Boston Alternative Energy Facility

Appendix B4 to Natural England's Deadline 7 Submission

**Natural England's Comments on Chapter 17 Marine and Coastal Ecology and
Appendix 17.1 Habitats Regulations Assessment Update [REP5-006]**

1st March 2022

TITLE **BOSTON ALTERNATIVE ENERGY FACILITY DEVELOPMENT CONSENT ORDER Regulation 5(2)(l)(i) and (ii) - Statutory and Non Statutory Sites and Features of Nature Conservation and Habitats Plan BOSTON BOROUGH COUNCIL - Sheet 1 of 1**

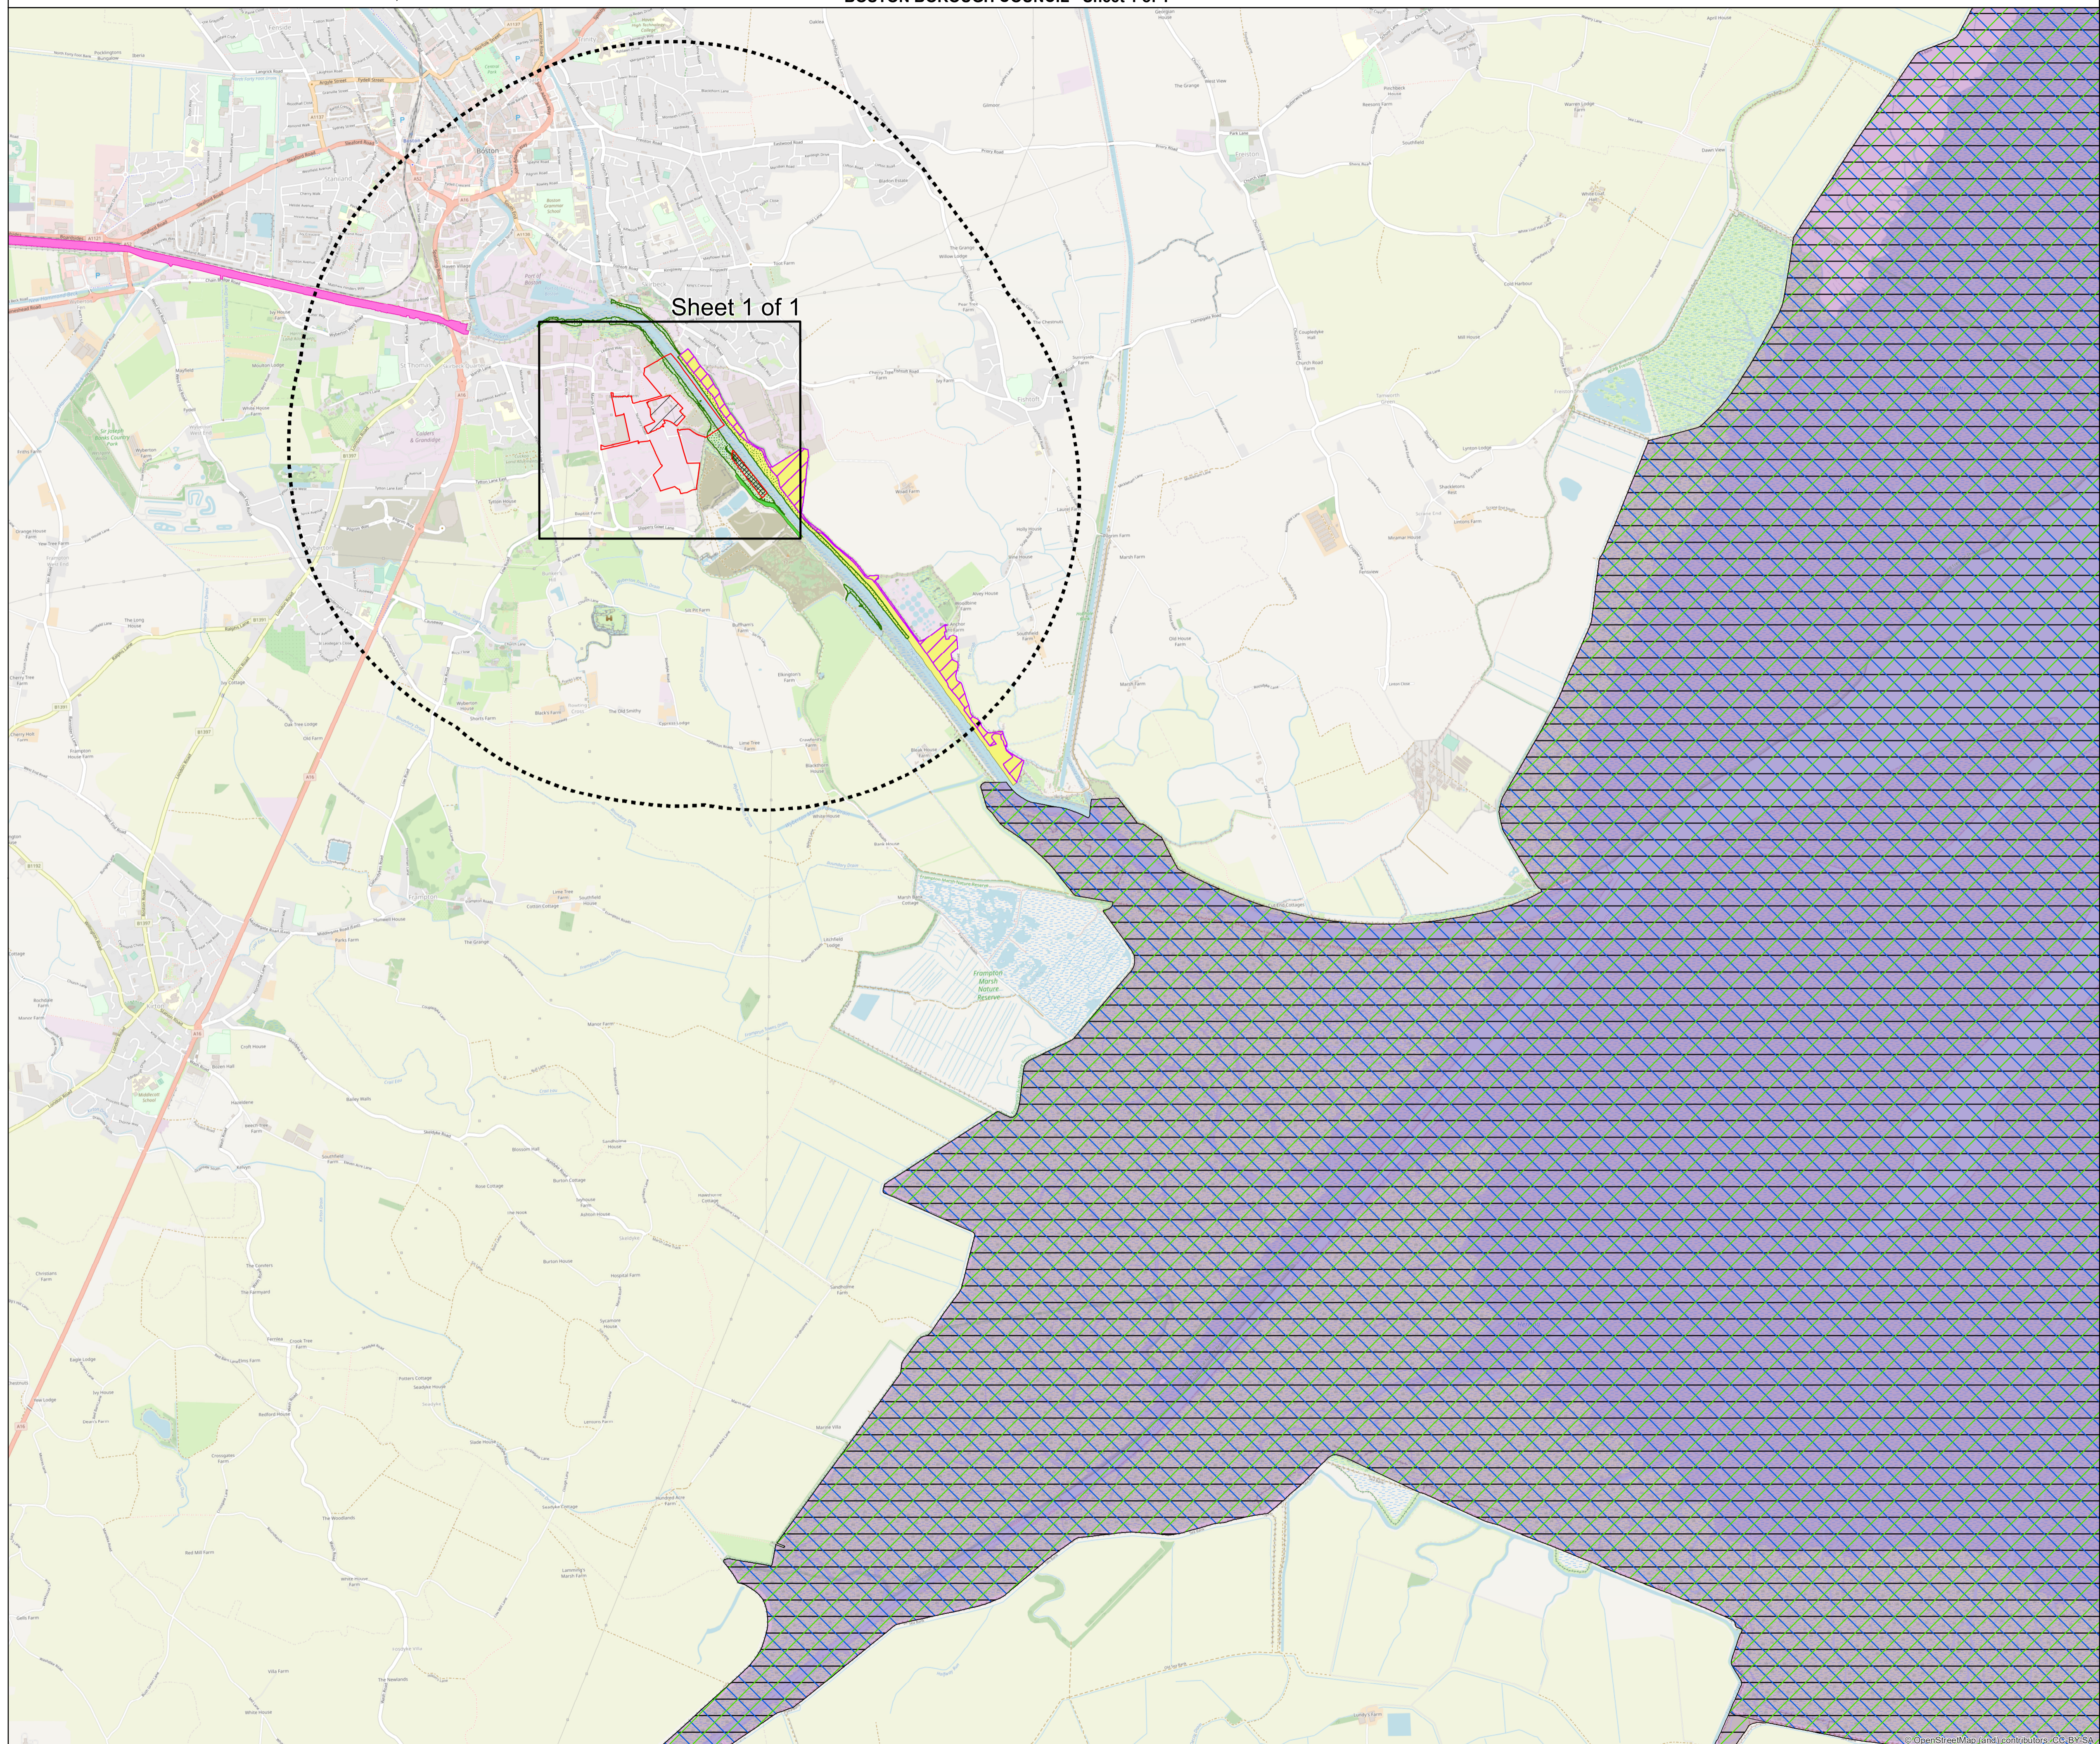
Paragraph No.	Comment	RAG status
1.	3.2.5	<p>NE continues to request further clarification on the proposed Habitat Mitigation Area - in particular regarding the removal of the low-profile banks. We specifically require details of where the bank will be removed, the method, a calculation of the volume of material to be removed and where this will be disposed of. In addition, the location of the created 3 shallow pools and methods used.</p> <p>Also, regarding the placement of rocks from the Principal Application Area to the proposed Habitat Mitigation Area - to facilitate roosting of Redshank - will these function in the same way as the remaining banks (Old sea wall) that is presumably not being removed? This may restrict visibility of predators.</p> <p>Natural England suggest one additional mitigation option here: restricting access by Members of Public and dog walkers onto the Habitat Mitigation Area from the Coastal Path using fencing. This would minimise disturbance if this area is being used more regularly by roosting birds. Signage actively asking Members of public to keep dogs on the lead (and why this habitat is important) would be beneficial.</p>

3.	3.5.3	Natural England's comment on paragraph 3.2.5 with regards to the use of the rocks within the proposed Habitat Mitigation Area applies here too.

4.	3.5.4	Natural England's comment on paragraph 3.2.5 with regards to dogs accessing the proposed Habitat Mitigation Area applies here too.	
5.	Table 3.1	<p>Natural England advises that the EA may require notification (Flood Permit) if works are undertaken along the banks of The Haven.</p> <p>Prior to the Boston embankment works, the saltmarsh along The Haven was cattle grazed in several places maintaining a short-sward with open bare patches. NE are uncertain whether grazing is still undertaken (due to the removal of the old fences). This may be something that could be looked into. The fences will have reduced the disturbance impact of dogs accessing the saltmarsh/mudflats from the PROW/ LNR. But habitat management may still need to be provided over the lifetime of the project.</p>
